2 Avondale Road, Bromley, BR1 4EP

Planning Letter

February 2024

This planning letter accompanies the revised application for a double-storey side extension with a rear wraparound at ground floor at 2 Avondale Road, Bromley, BR1 4EP. Please note that the pre-app design did not consist of the already approved 6m rear extension along the adjoining neighbouring property, hence this new design incorporates all the points raised in the pre-app along with the addition of the approved 6m rear extension through prior approval. It responds directly to the feedback received from the pre-application officer's report, addressing key design considerations and policy compliance as outlined in the Local Plan, specifically referencing Policy 37 related to design standards and Policy 8 concerning side space provisions.

Number:
A101

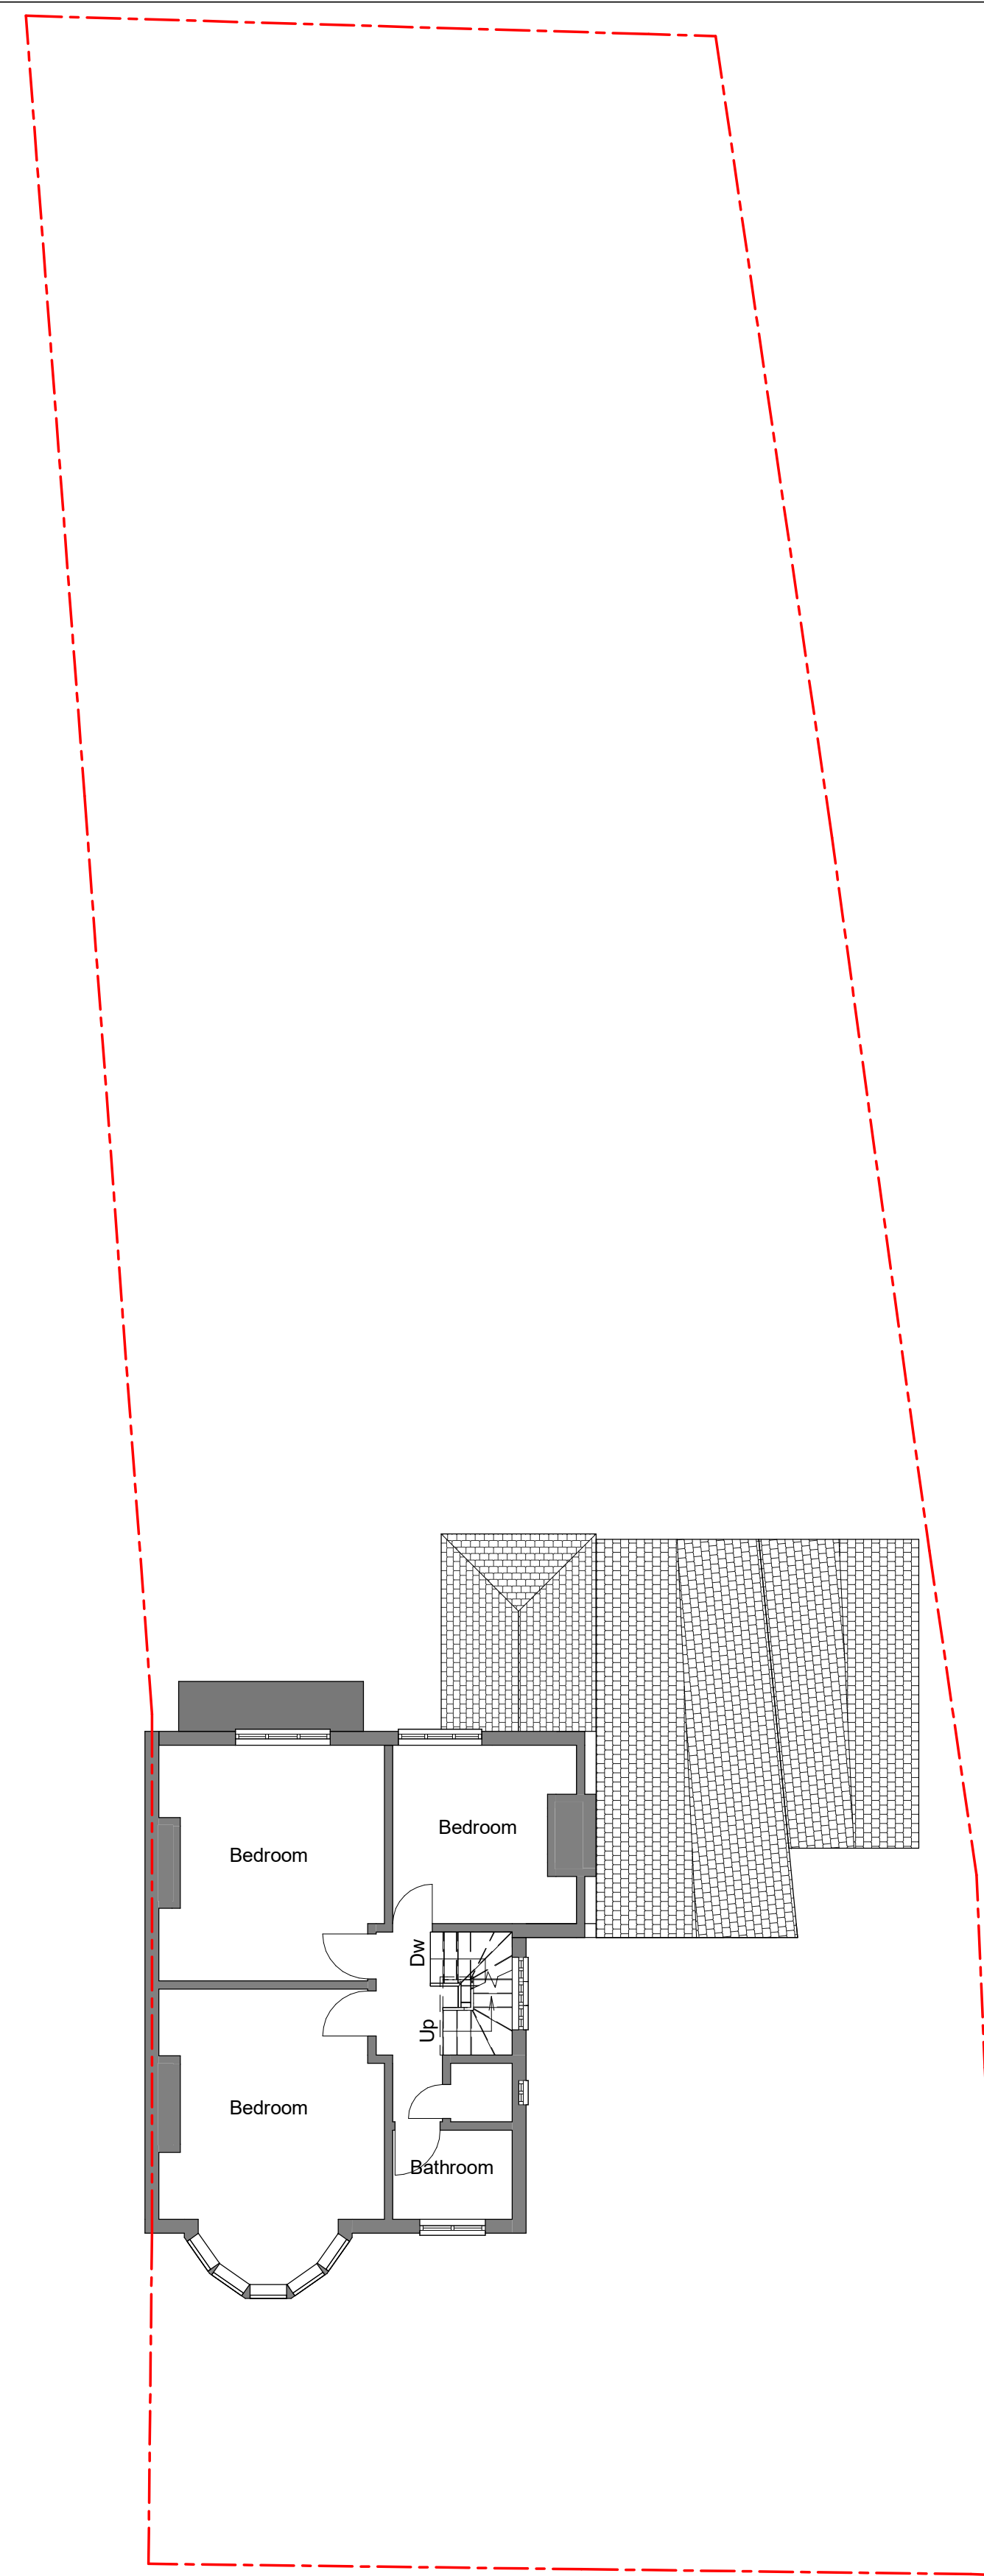
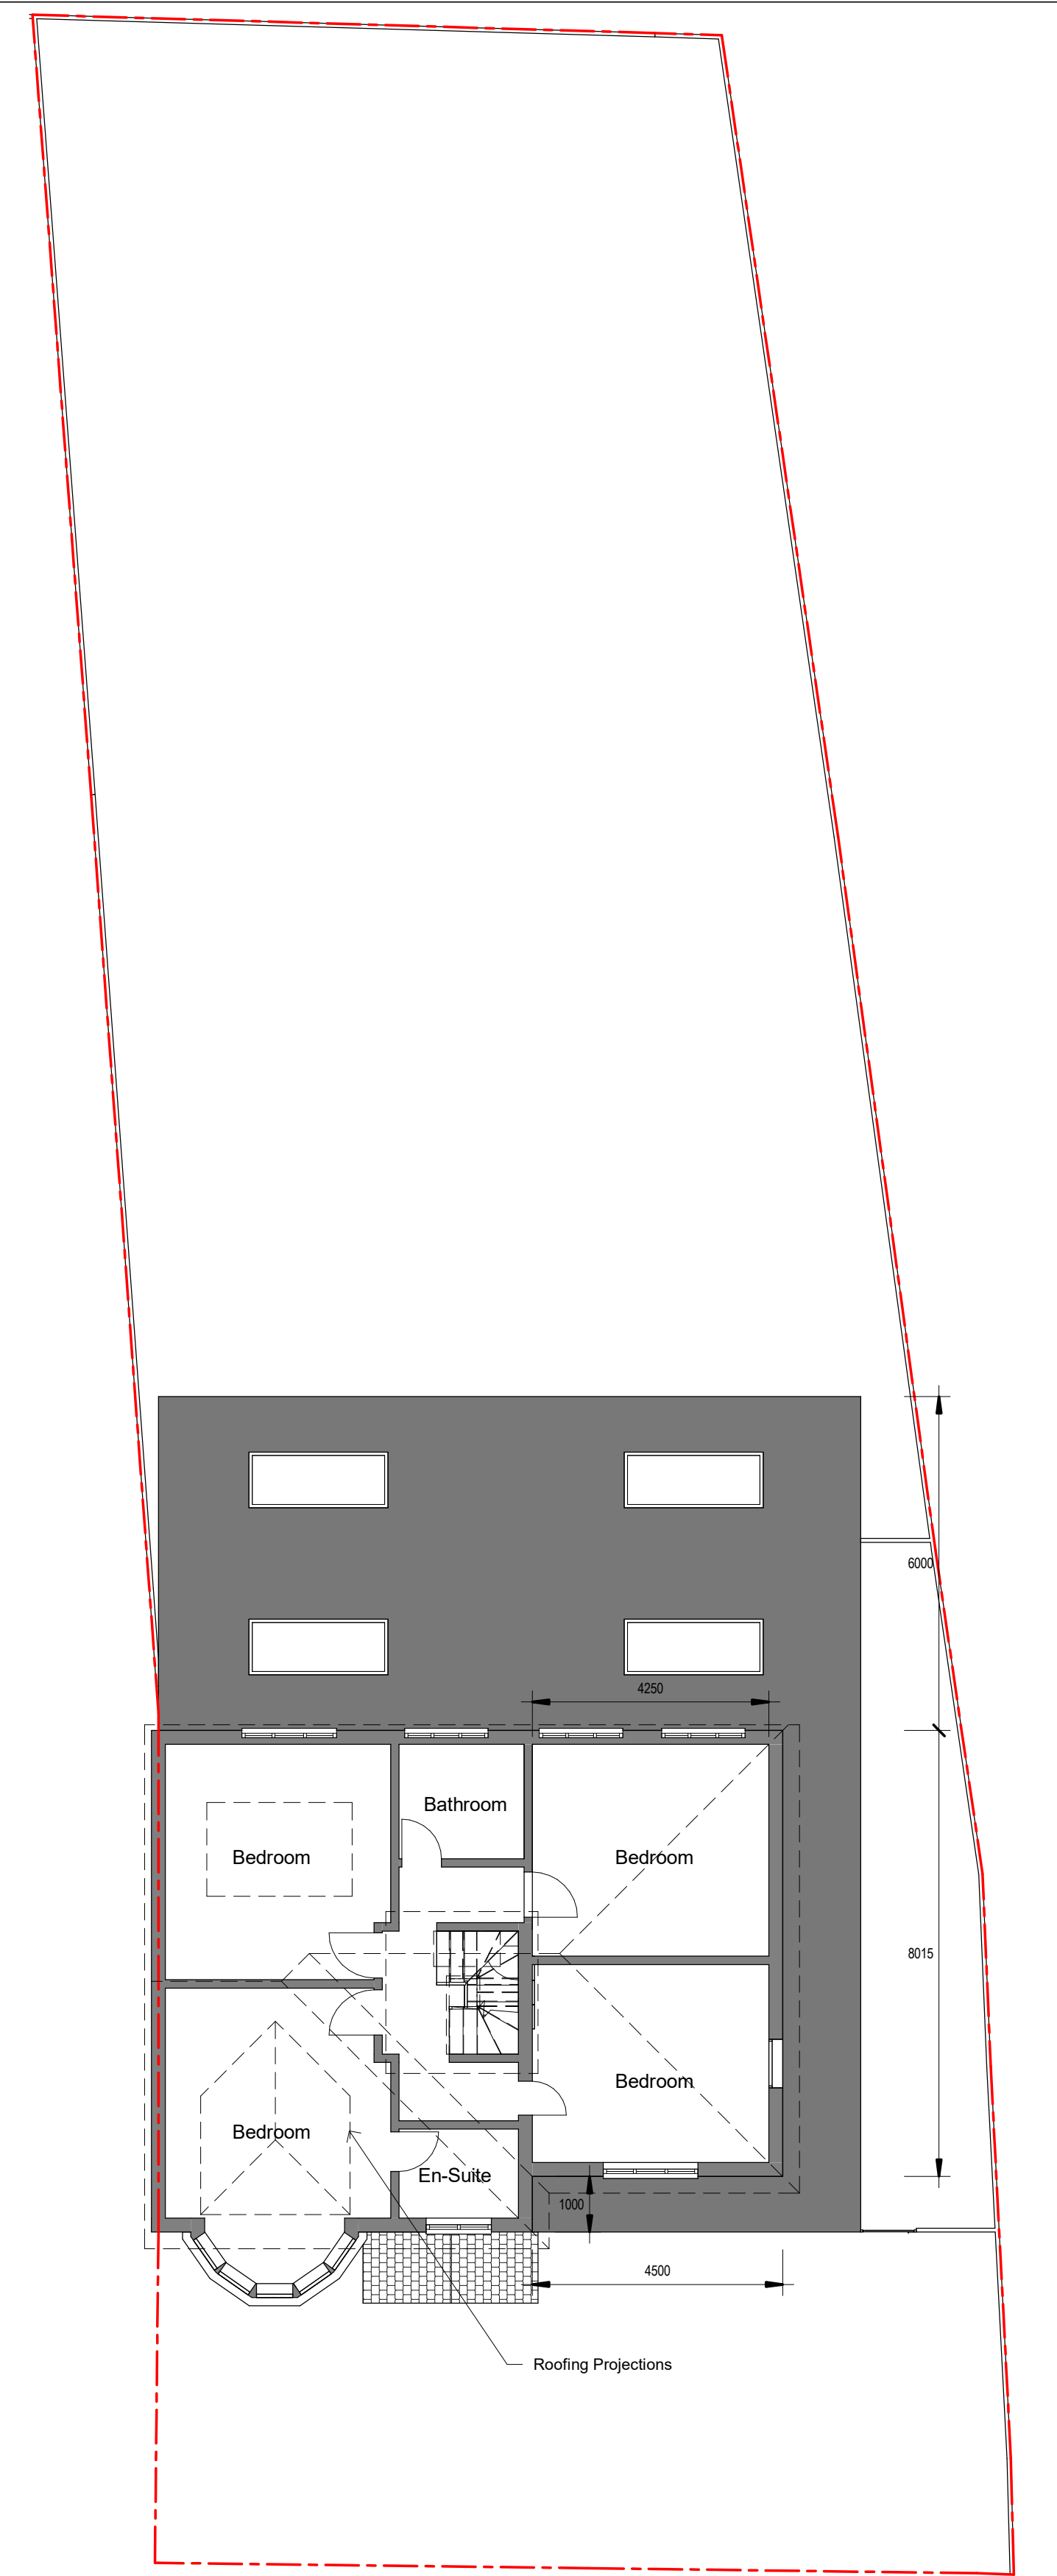
- **Front Wall Offset:** In response to the recommendation for the two-storey side extension to provide visual subservience to the original dwelling, the front wall of the first-floor side extension has been offset by 1 meter. This adjustment ensures that the new development does

- **Side Space Provision:** Acknowledging the importance of maintaining adequate side space as per Policy 8 of the Local Plan, the revised design now includes a 1-meter gap from the edge of the boundary to the new extension at the rear of the property. This modification respects the existing spatial standards within the area and addresses the concerns raised regarding the previous scheme's proximity to the boundary line. Please note that the proposed side extension on the ground floor has been reduced by almost one meter in width from the pre-planning design, meaning that the gap at the front of the property is far more than 1m, in fact it is almost 2.5m.
